Online Comment

Application H16-0042-26
Location THE CHANTRY 7 CHURCH STREET SPALDING PE11 2PB
Proposal Works to include replacement windows and doors, repointing, new clay chimney pot and removal of internal wall between kitchen and dining room above counter level only

Name Ruben Lopez Catalan
Address Lincolnshire County Council, County Offices, Newland, Lincoln LN1 1YL
LN1 1YL

Date Submitted 03-02-26
For/Against Comments

Part Plan & Elevations as Proposed

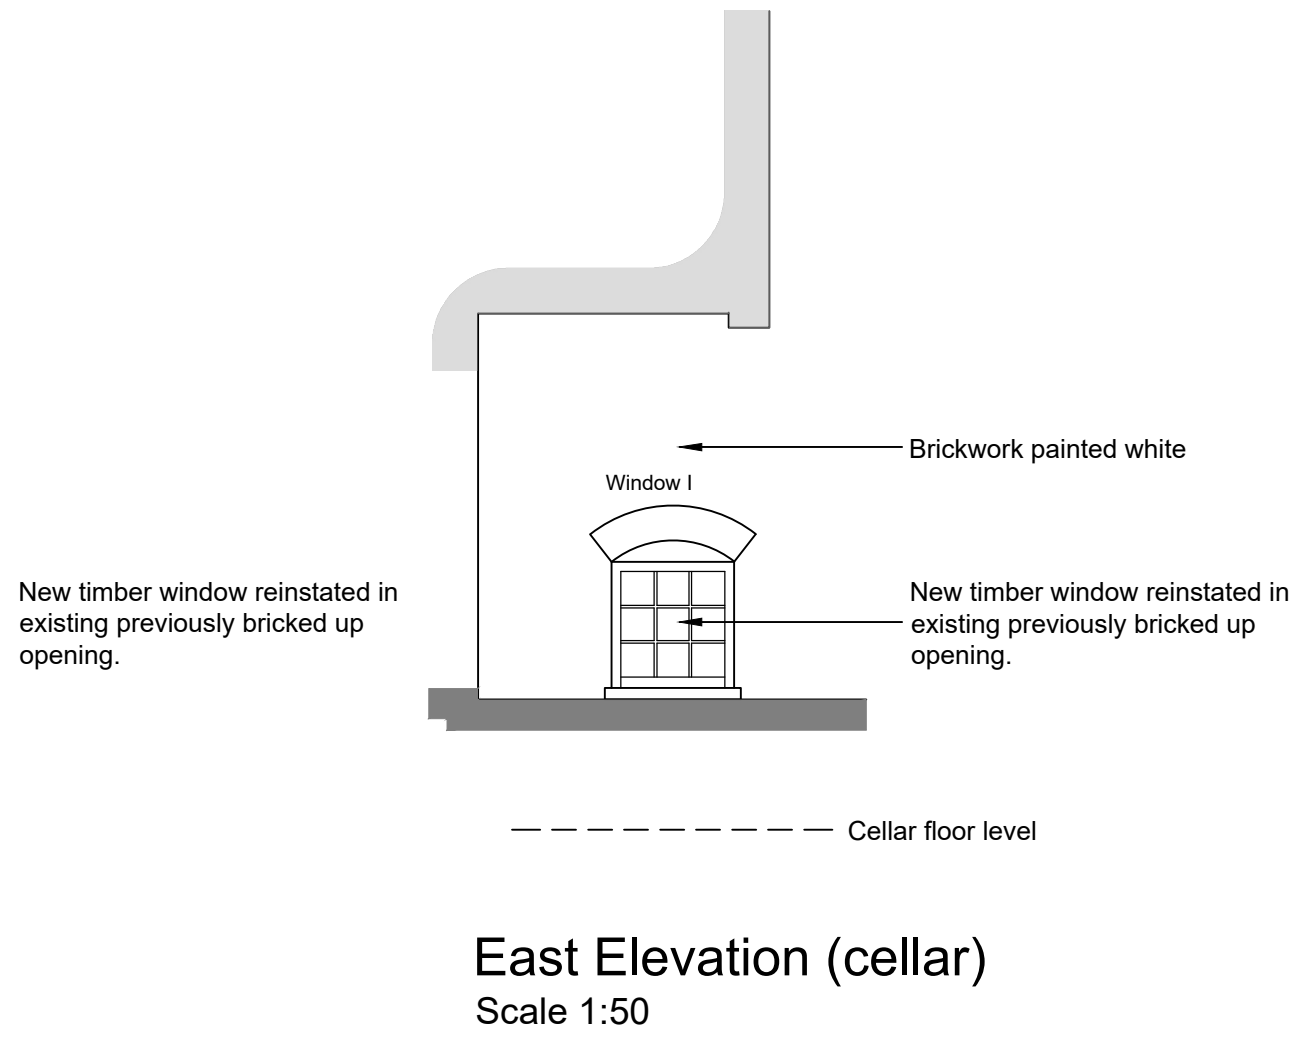
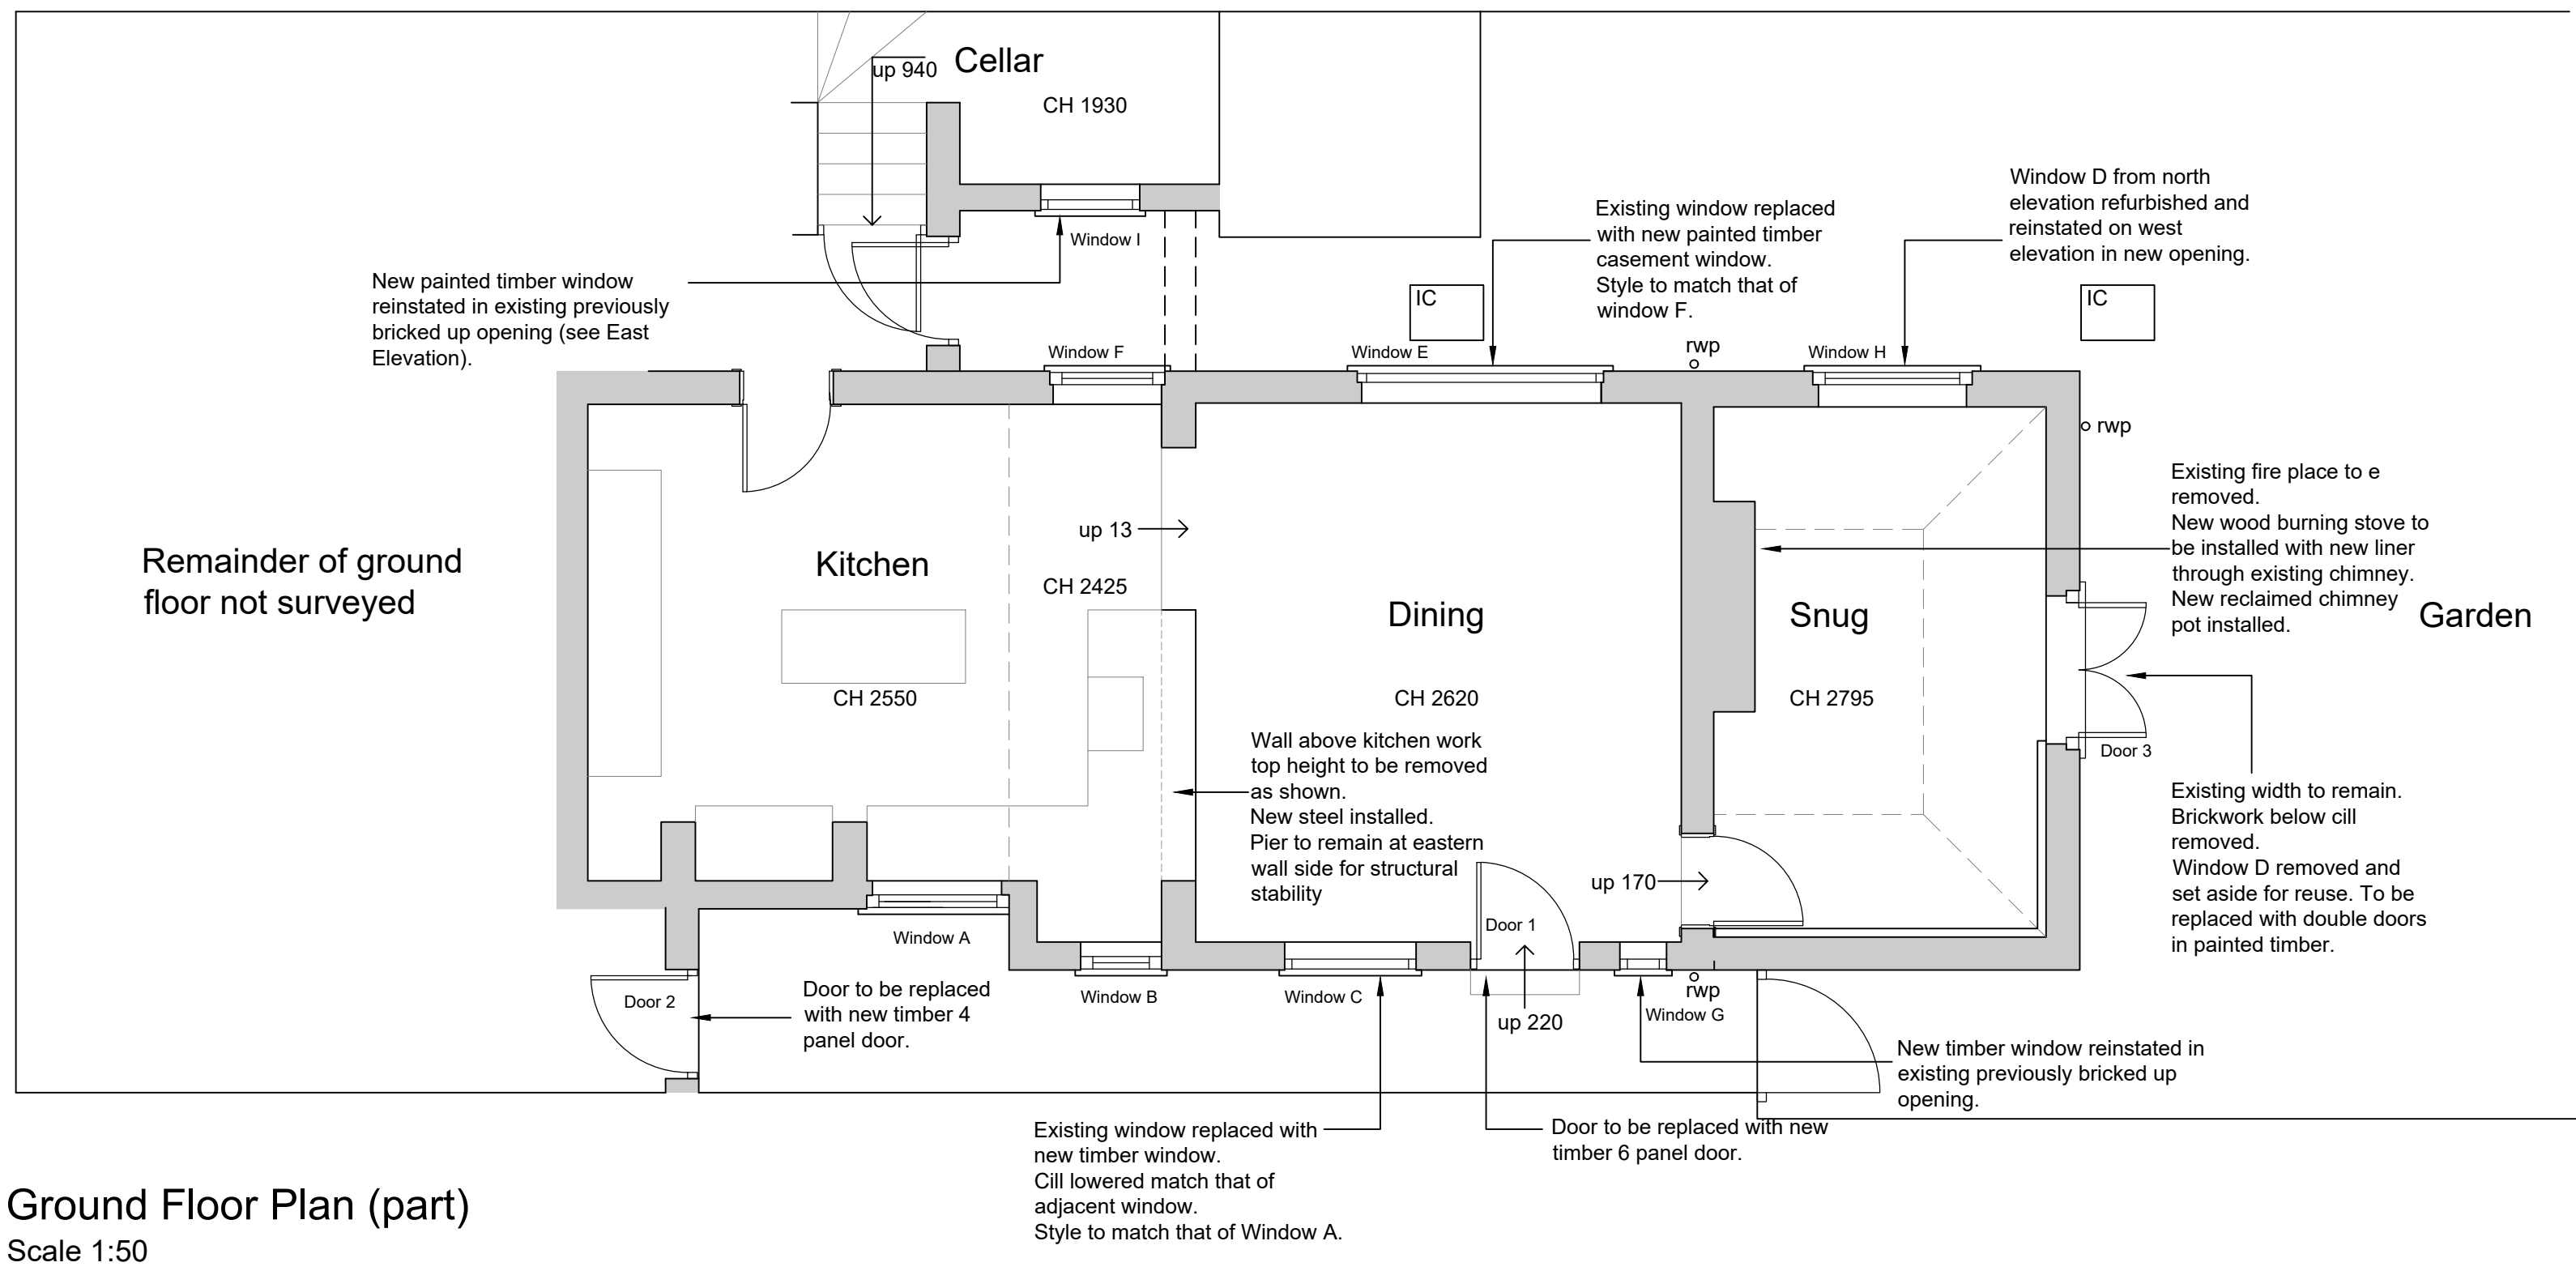
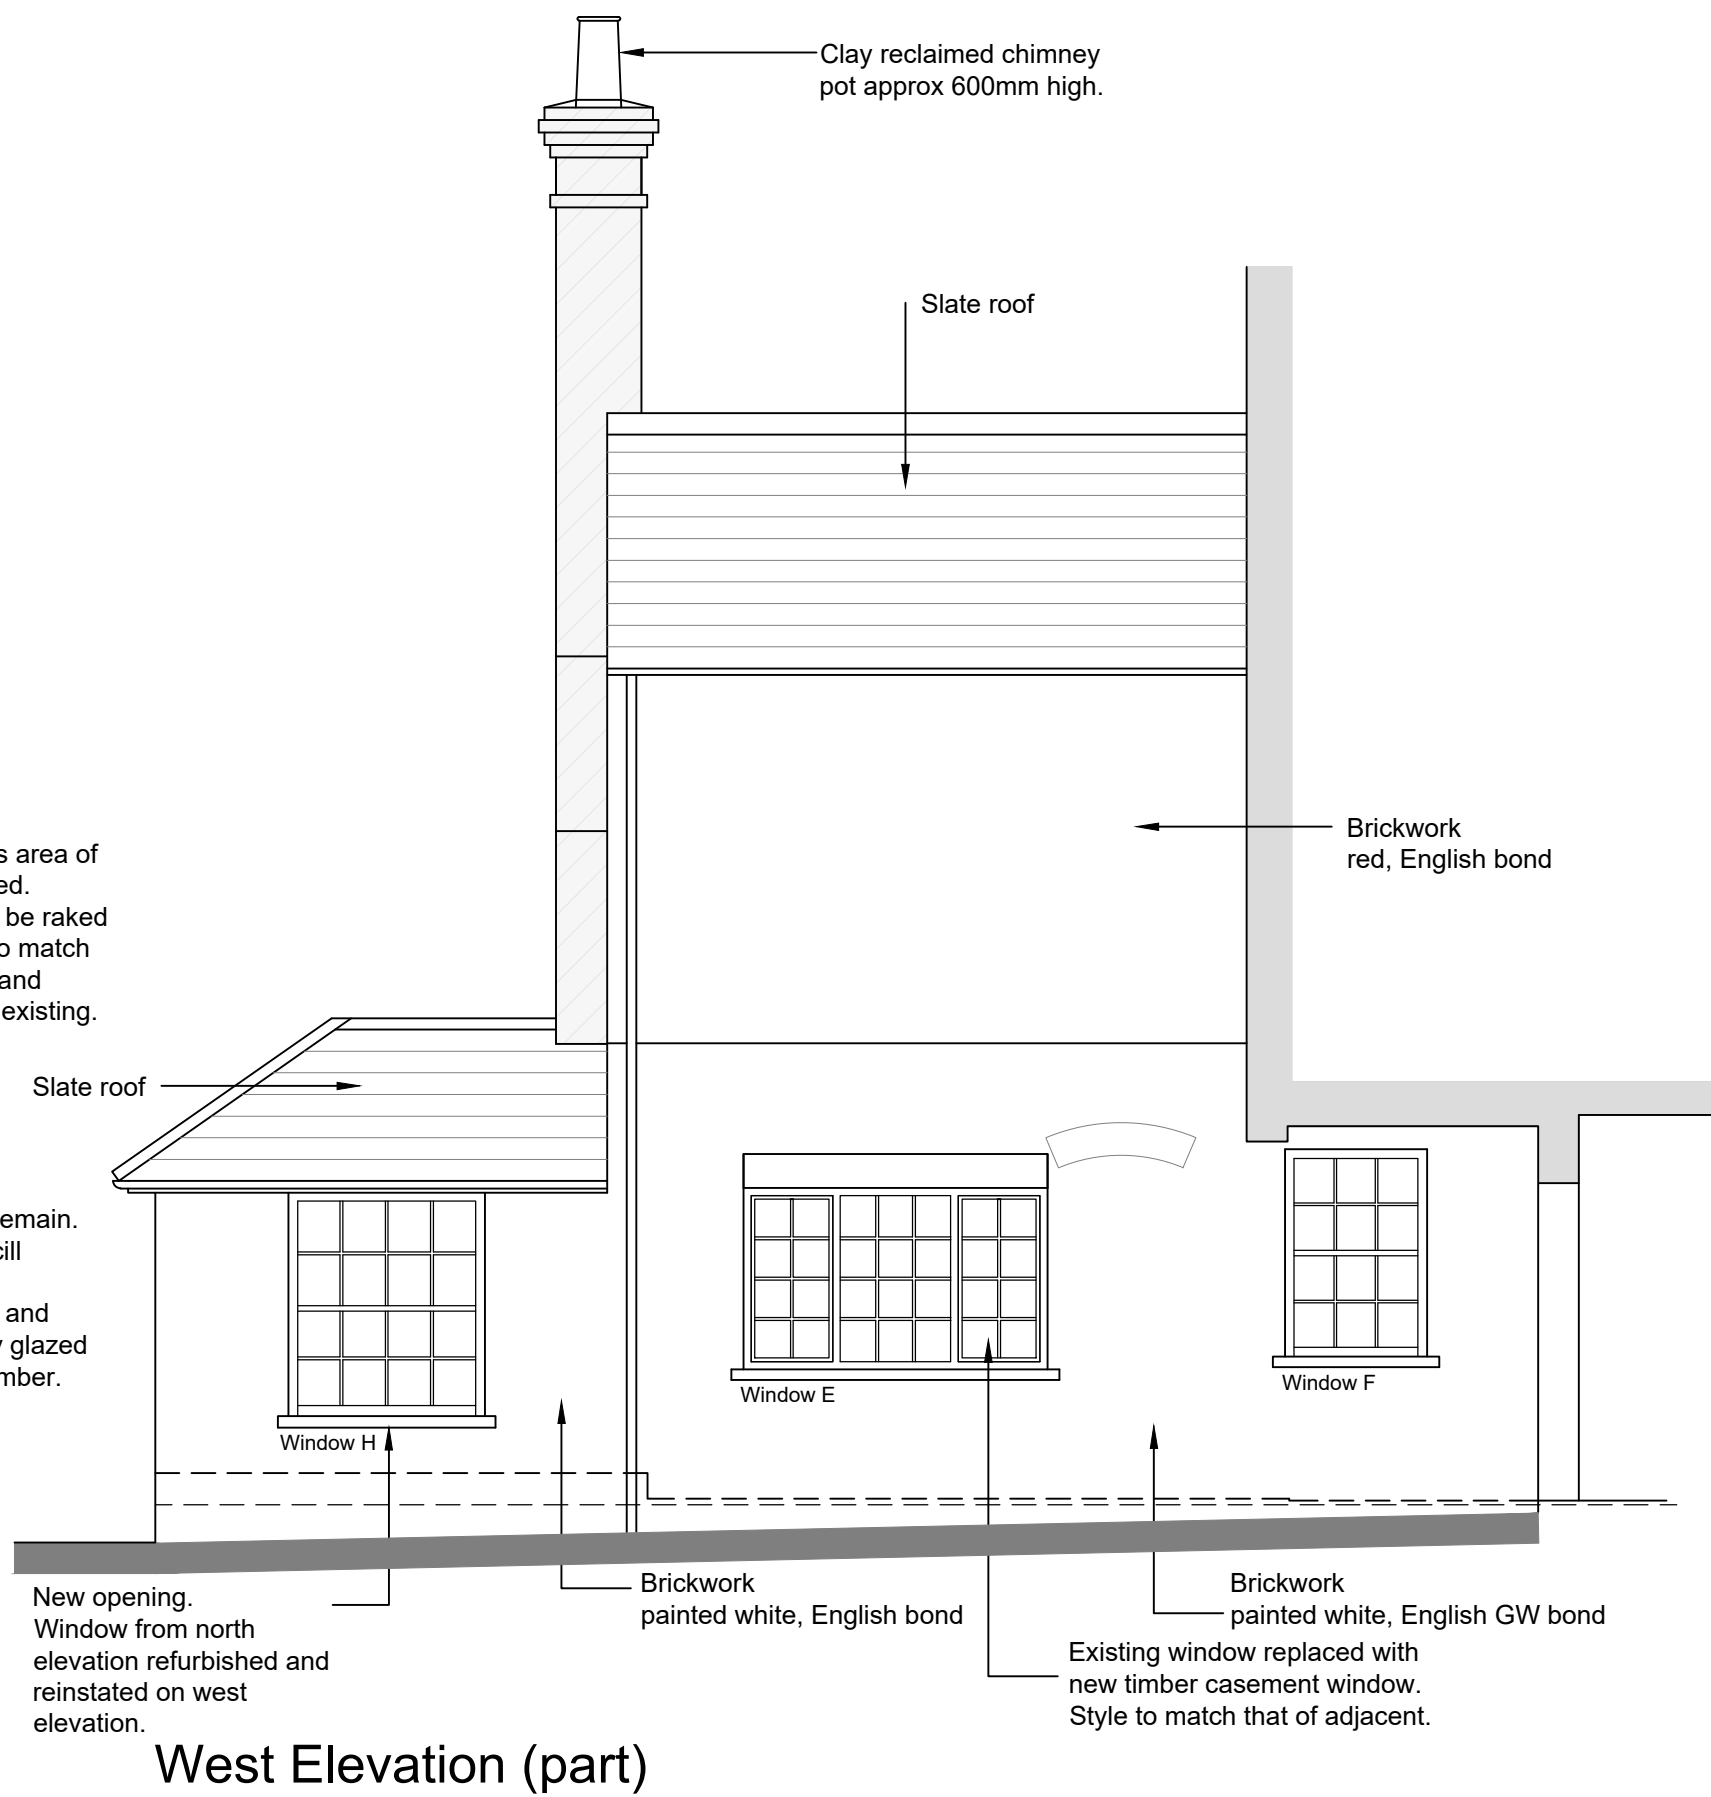
This will comprise a programme of pre-development mitigation works, including a Level 1 historic building recording of the HIA identified items 1, 5 and 6 (1. Partial removal of the internal wall between the kitchen and dining area; 5. Replacement of Window D with Door; and 6. Relocation of Window), to be undertaken in accordance with Historic England's Understanding Historic Buildings: A Guide to Good Recording Practice (2016).

We recommend that, if permission is granted, a condition be attached requiring a mitigation strategy to effectively address this site.
